Engineers Comments Regarding Surface Water Drainage

Application Reference:	WA/28/26/DOC	Reviewer Reference:	ADC/EXT5/AF
Planning Officer:	Amber Willard	Date of Review:	30/04/2026
Site Name:	Stoneybrook Farm Eastergate Lane Walberton BN18 0BA		
Application Description:	Approval of details reserved by condition under WA/108/24/PL relating to condition 3- Surface Water Drainage.		
Assessment Number:	1

Condition 3: **Objection**

A001-013/101

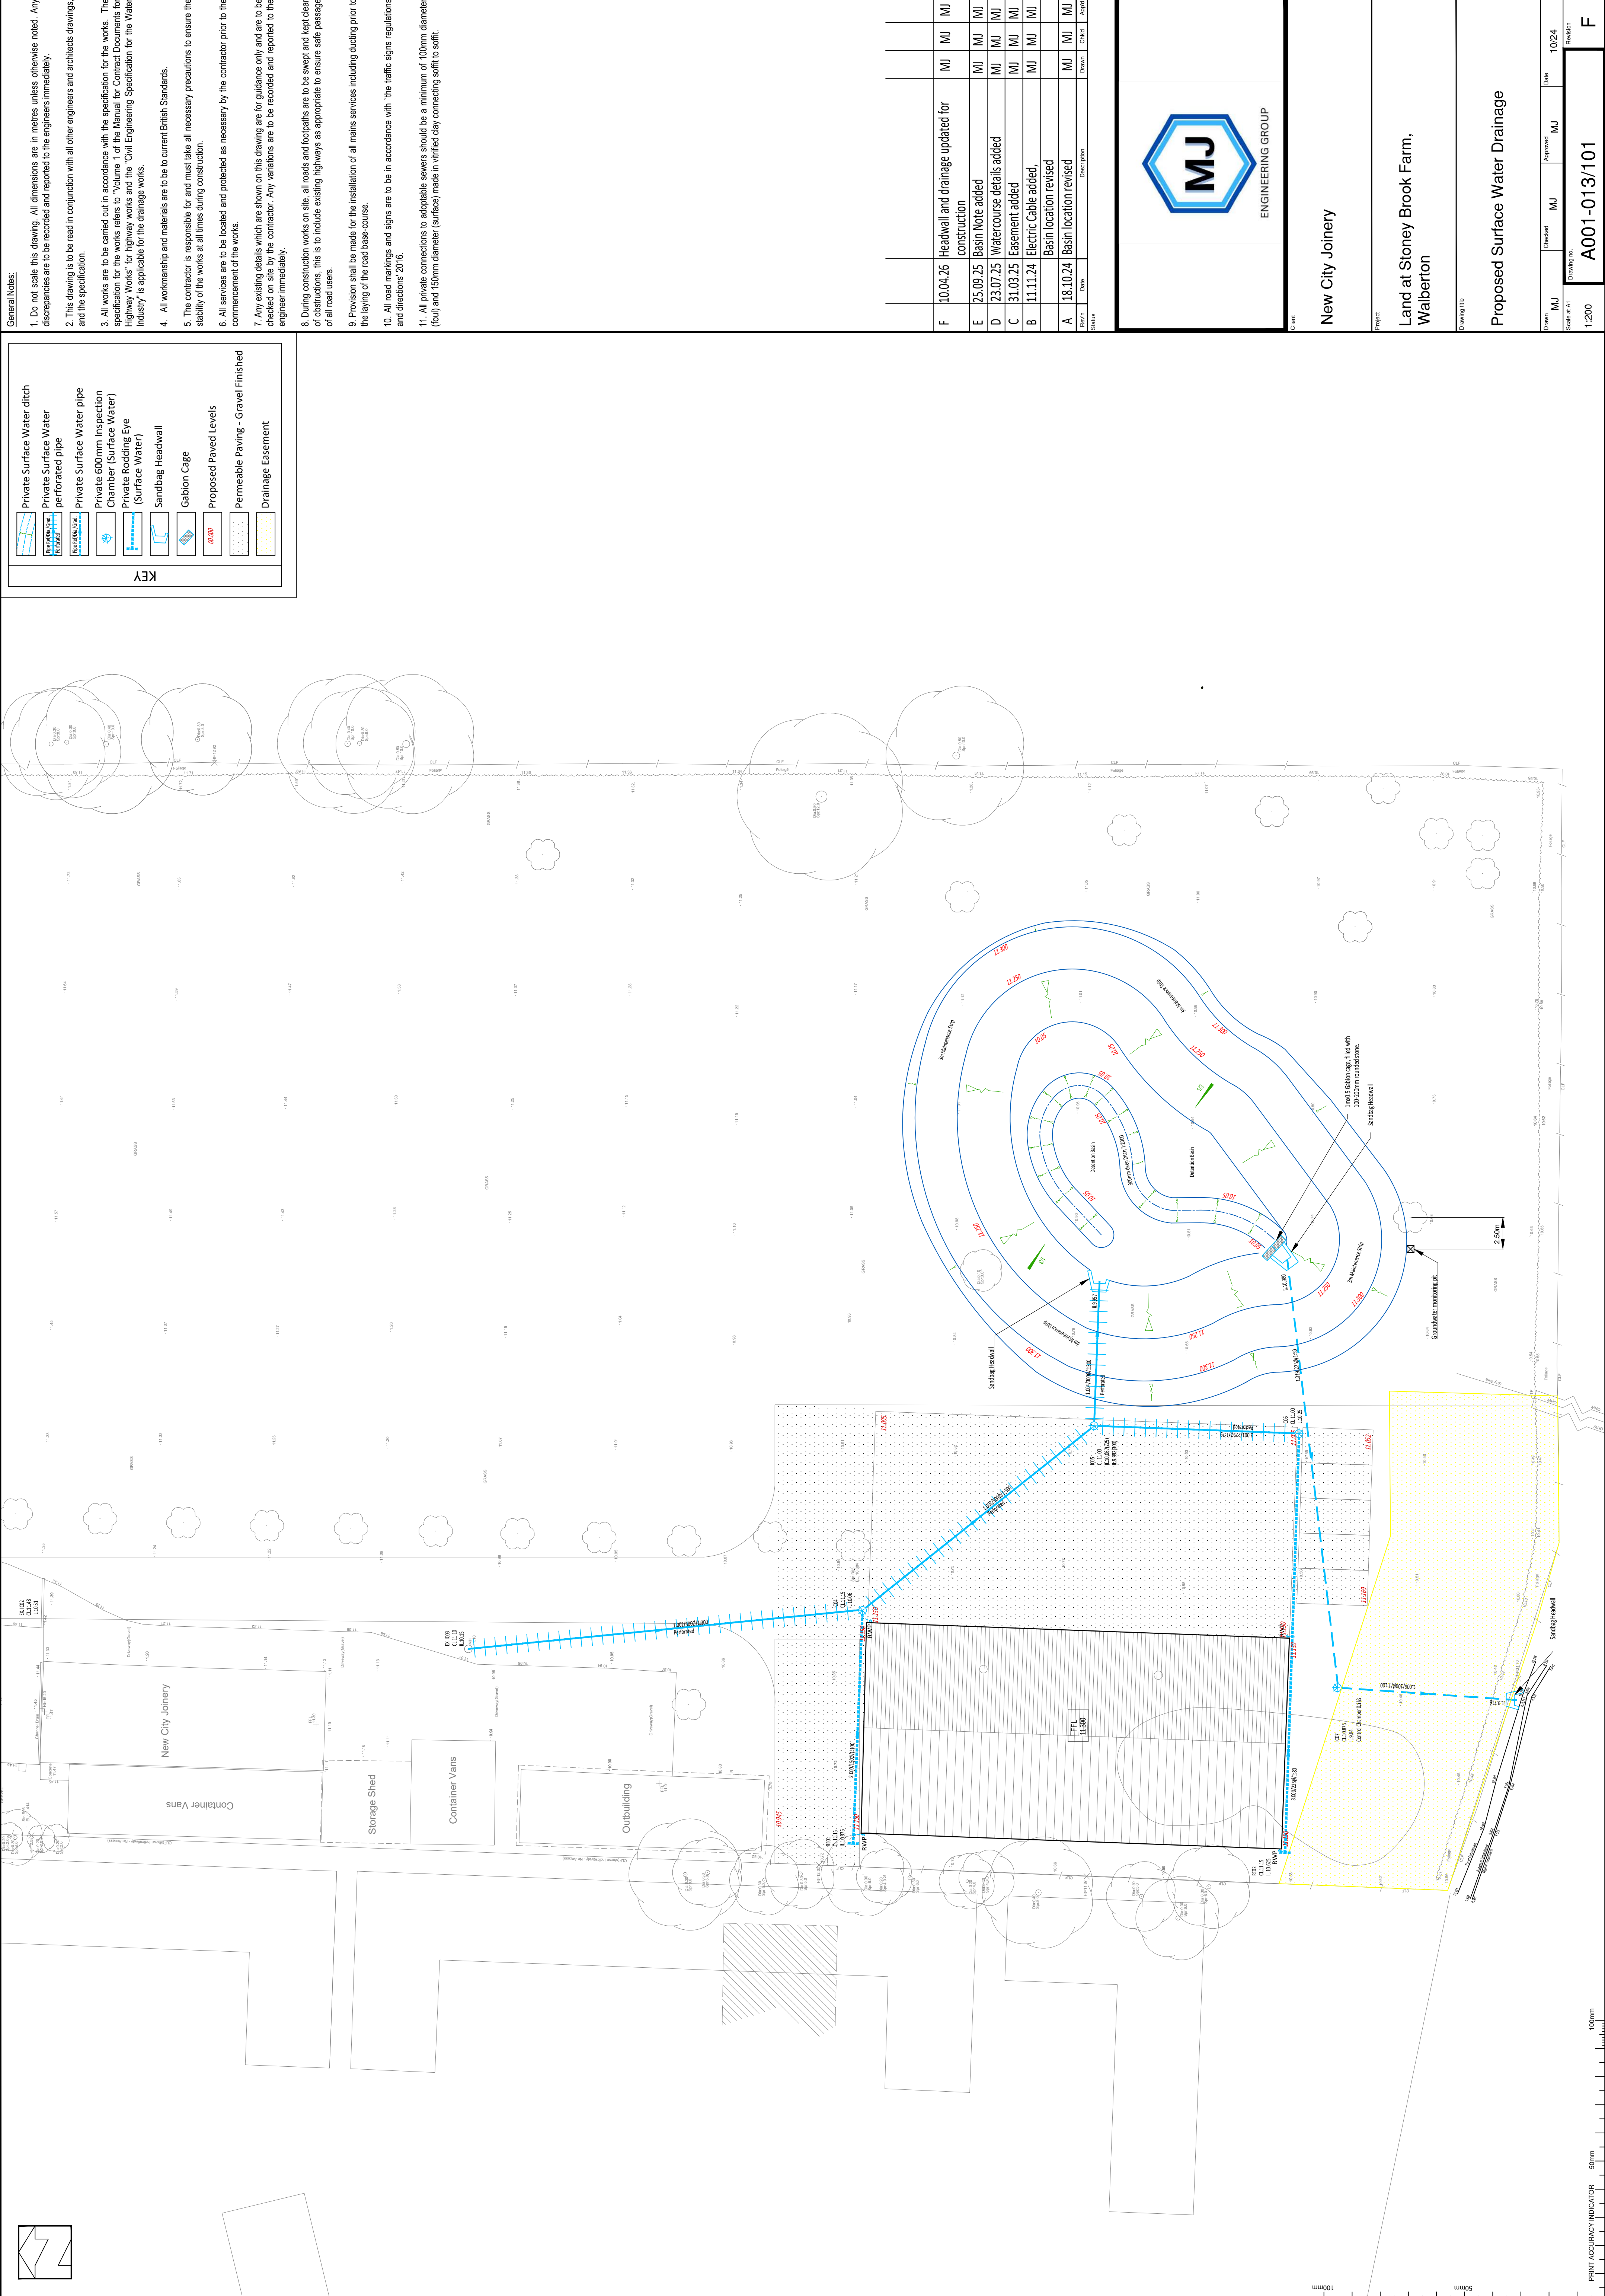
ADC Drainage Comments	Designer Response			
Date:	30/04/2026				
Condition Number: 3					
Comment Number					
1.	Designs, sizing and details for the proposed rainwater harvesting should be provided.				
2.	Greenfield runoff calculations should be provided for the drained area.				
3.	The use of the pond for interception drainage is not suitable as the top water level would be at the overflow level during winter.				
4.	The full ground investigation report should be provided.				
5.	Anti-floatation calculations should be provided for the basin.				
6.	Construction details should be provided for the basin construction and liner.				
7.	Measures to mitigate blockage of the flow control device should be

incorporated at the basin headwall and flow control chamber.				
8.	The diversion of the existing system into the basin/pond increases the drained area beyond the development boundary. The drained areas should be clarified on plan. The area of the basin should also be included in the drained areas.				
9.	Due to the low discharge rate, the half-drain time for the basin during the 3.3% AEP + CC should be demonstrated to be less than 24 hours.				
10.	The surcharged outfall should be clarified in the calculations.				
11.	Can the flooding from existing the chamber shown in the calculations be alleviated or contained within the design?				
12.	Evidence of Ordinary Watercourse Consent from the LLFA or Land Drainage Bylaw Consent from ADC will be required. Website link here: Land drainage byelaws for landowners Arun District Council				
13.	A Maintenance Plan should be provided.
